PL- Consultation- Parks and Landscapes response

Application ref: BE/15/26/PL

Description: Erection of a 3-storey building comprising of under-croft car parking and bicycle store, 2 floors of 4 No self-contained flats on each (8 No flats in total) with pedestrian access formed onto Ash Grove. This application is in CIL Zone 4 (Zero Rated) as flats.

Location: Land East of Heath Place Bersted PO22 9SL

Proposed Site Plan
1:200

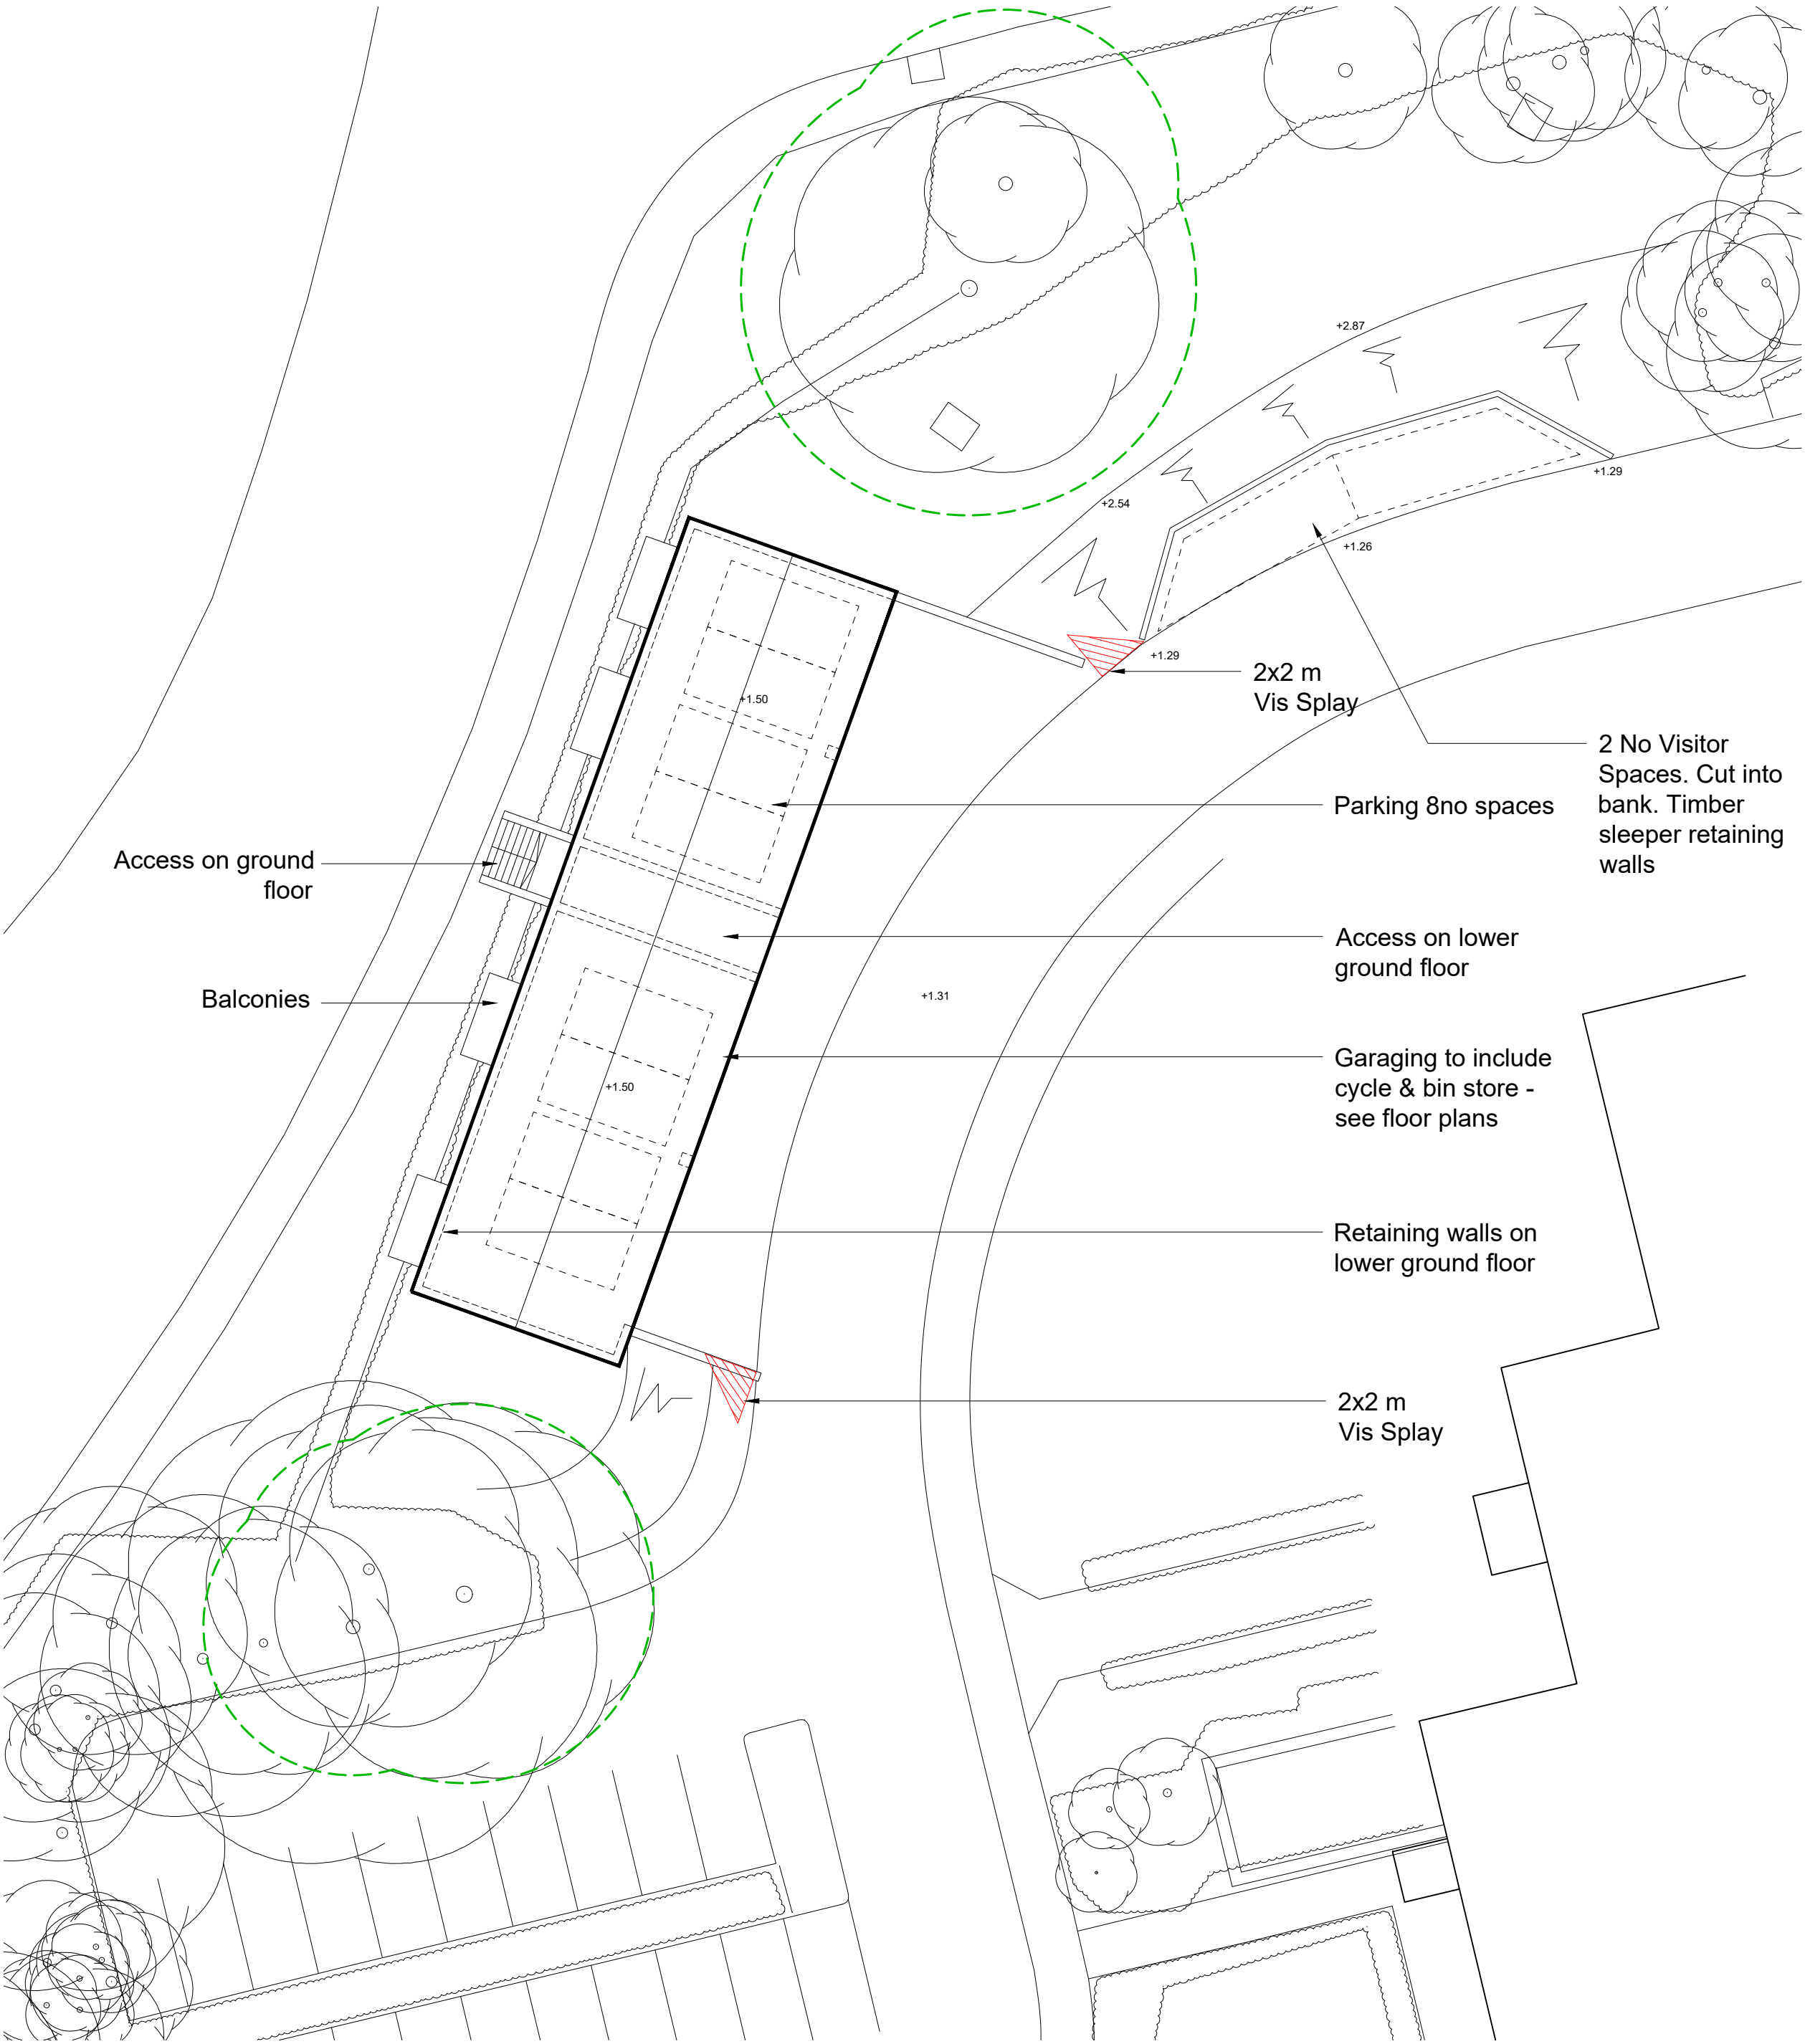
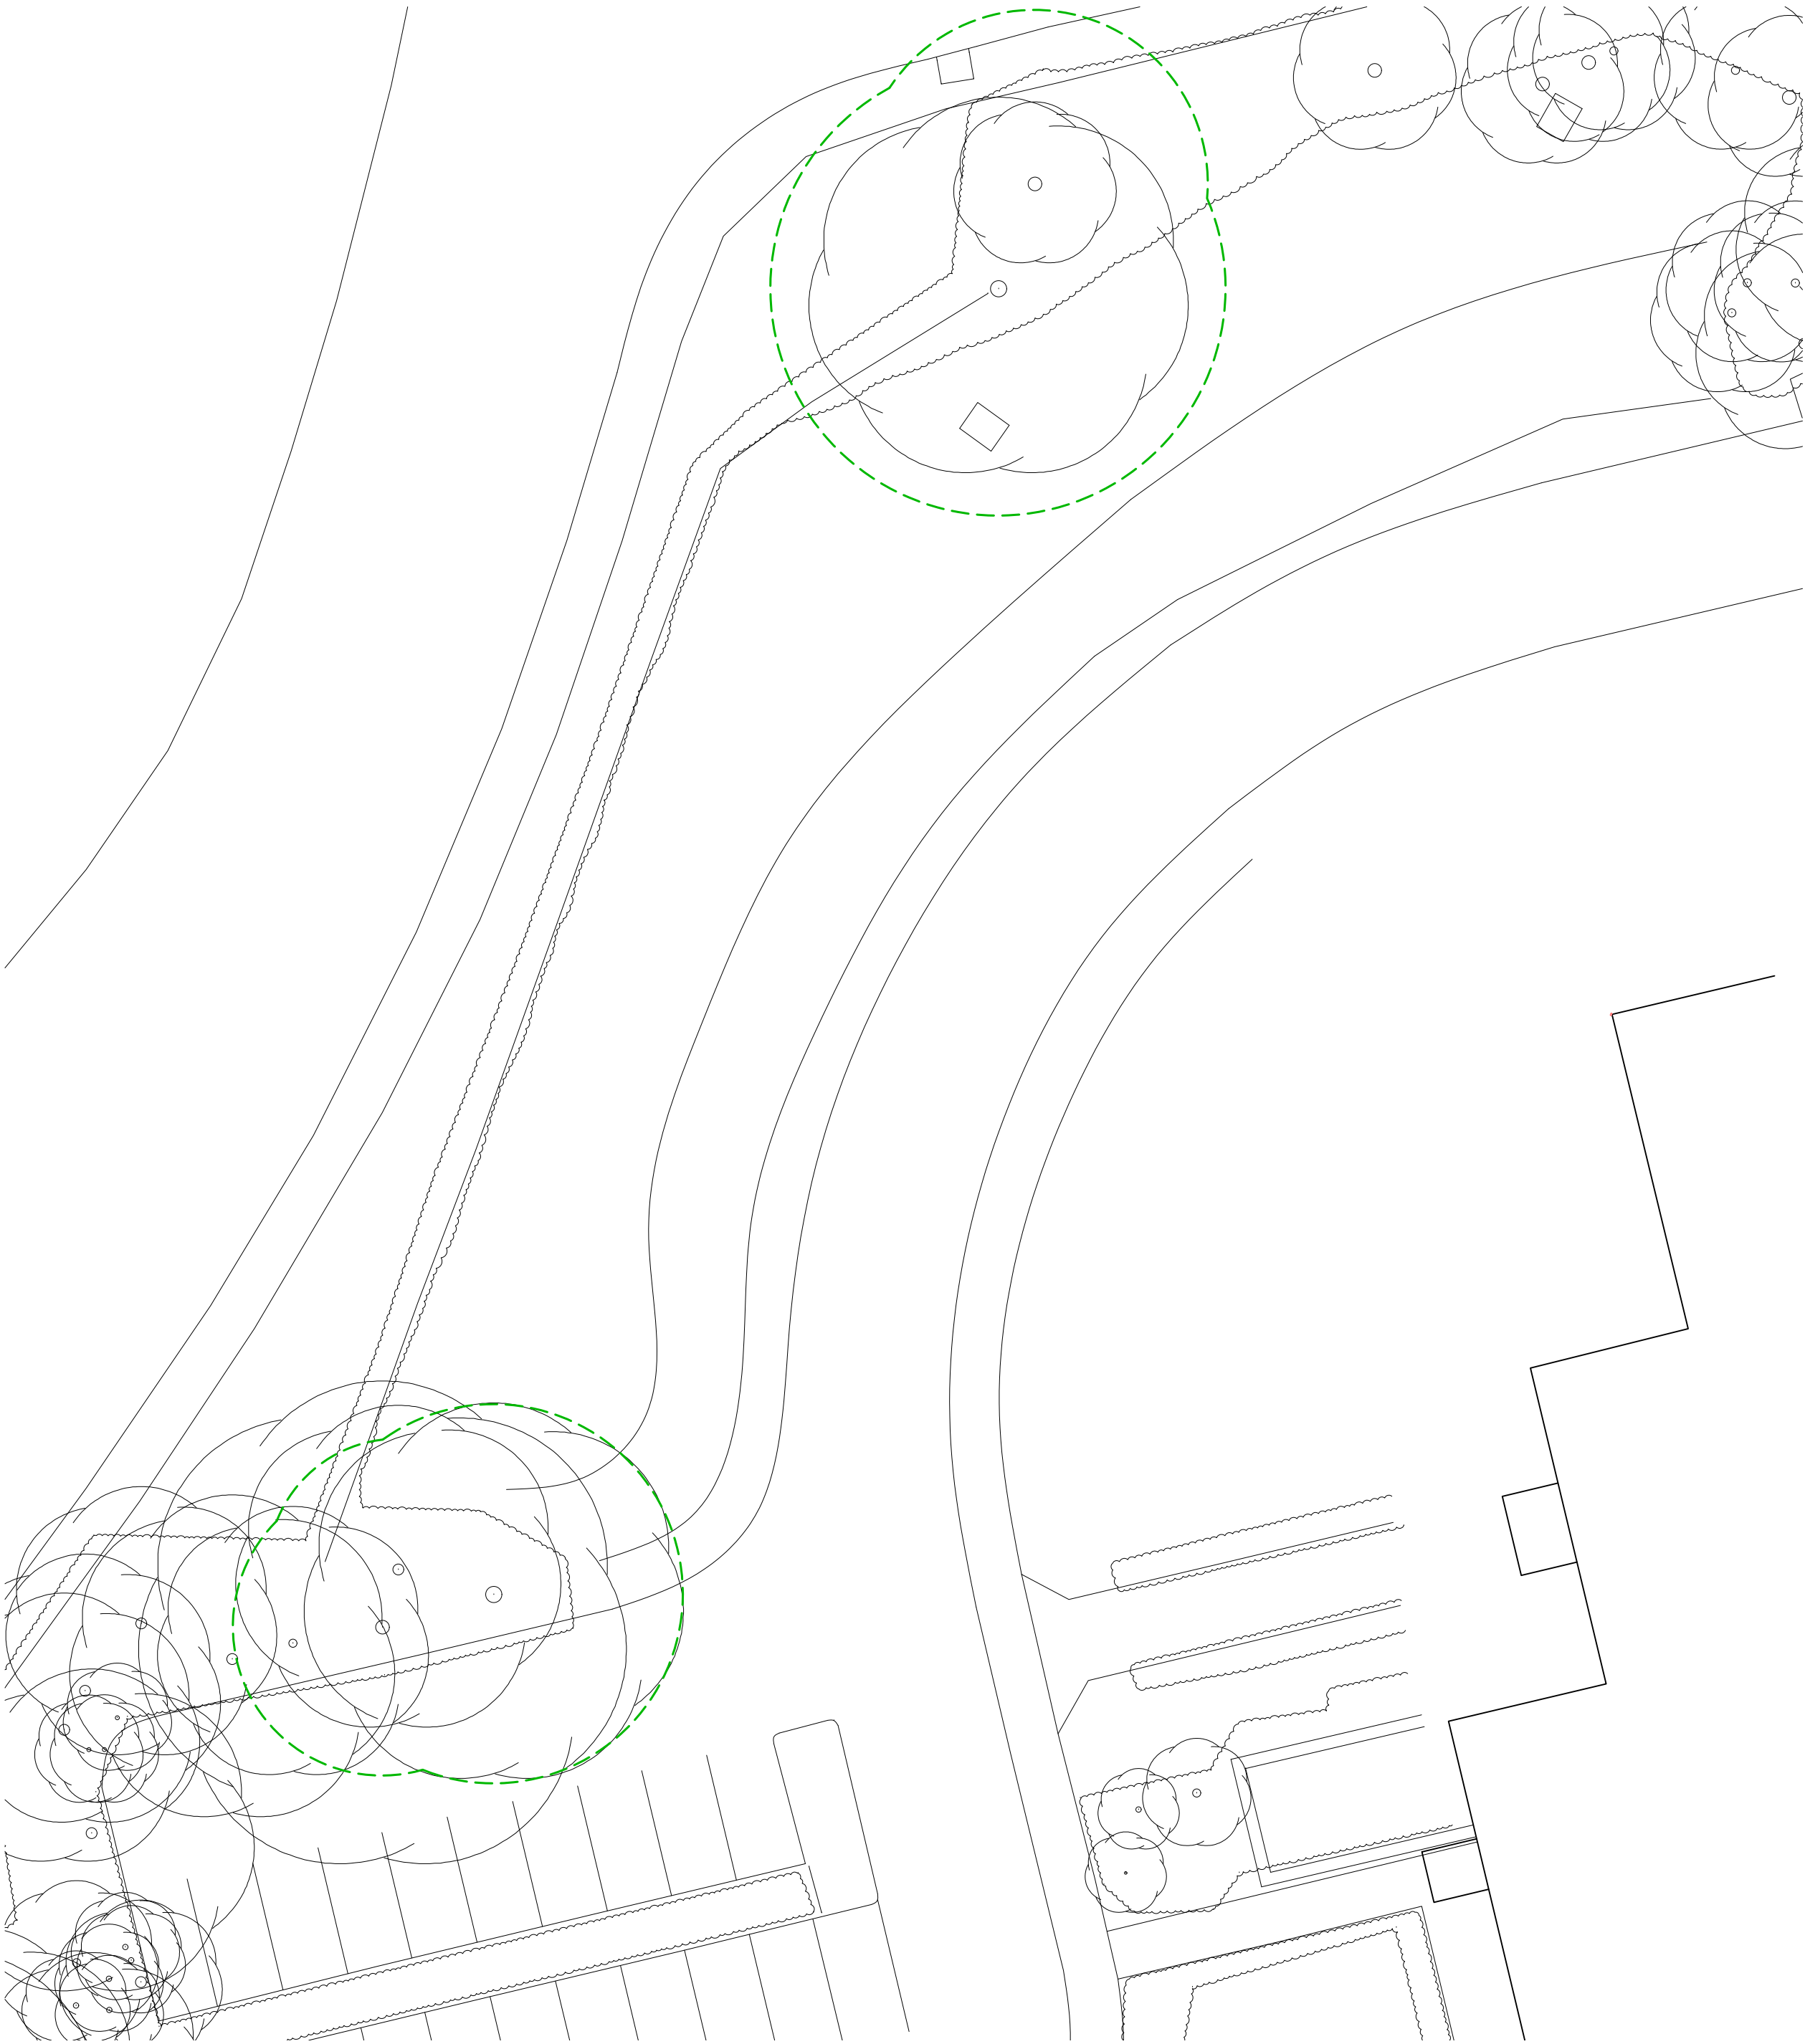
Outdoor amenity space is shown to be provided either side of the building enclosed by new planting and retention of the existing mature trees.

The external amenity areas is detailed to be largely retained with additional border planting added to maintain the appearance of the site and appearance on the street scene. This approach would make best use of the site retained natural environment (advised by the LPA Design Guide)

Further detail re the landscaping proposed would need to be submitted for approval in plan form detailing species, quantities, planting densities and size at time of planting.
